**Sent:** 23 July 2014 15:37  
**To:** Anita Gardner  
**Subject:** Your ref : FG/83/14/PL

I am writing in relation to to the above referenced planning application by the owners of 116 Ferring Street to construct a loft conversion. We are next door neighbours at 122 Ferring Street.

SECTION A-A

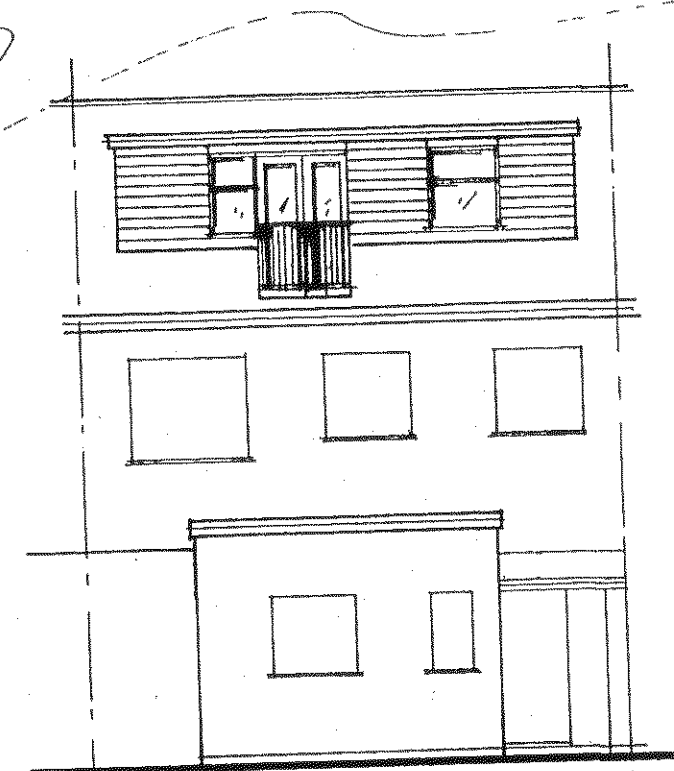
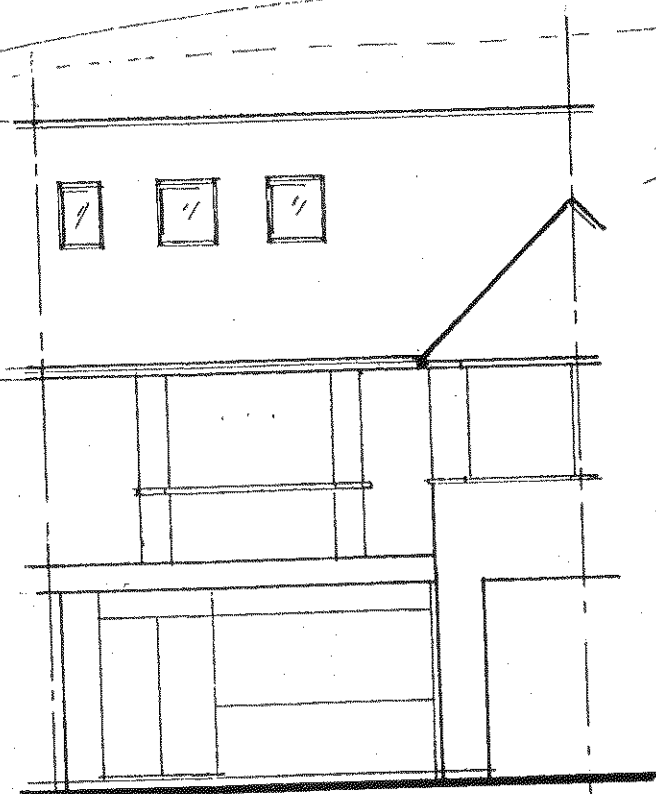
You'll see the "Section A-A" part of the attached plan has a food prep area with a "kitchen" marked on the first floor. Currently the rear section of the building is single story. The part marked "side elevation" gives the impression that the first floor is being extended up to the level of the gabled roof. The part marked "Second Floor Plan" shows a balcony with an adjacent "Flat Roof".
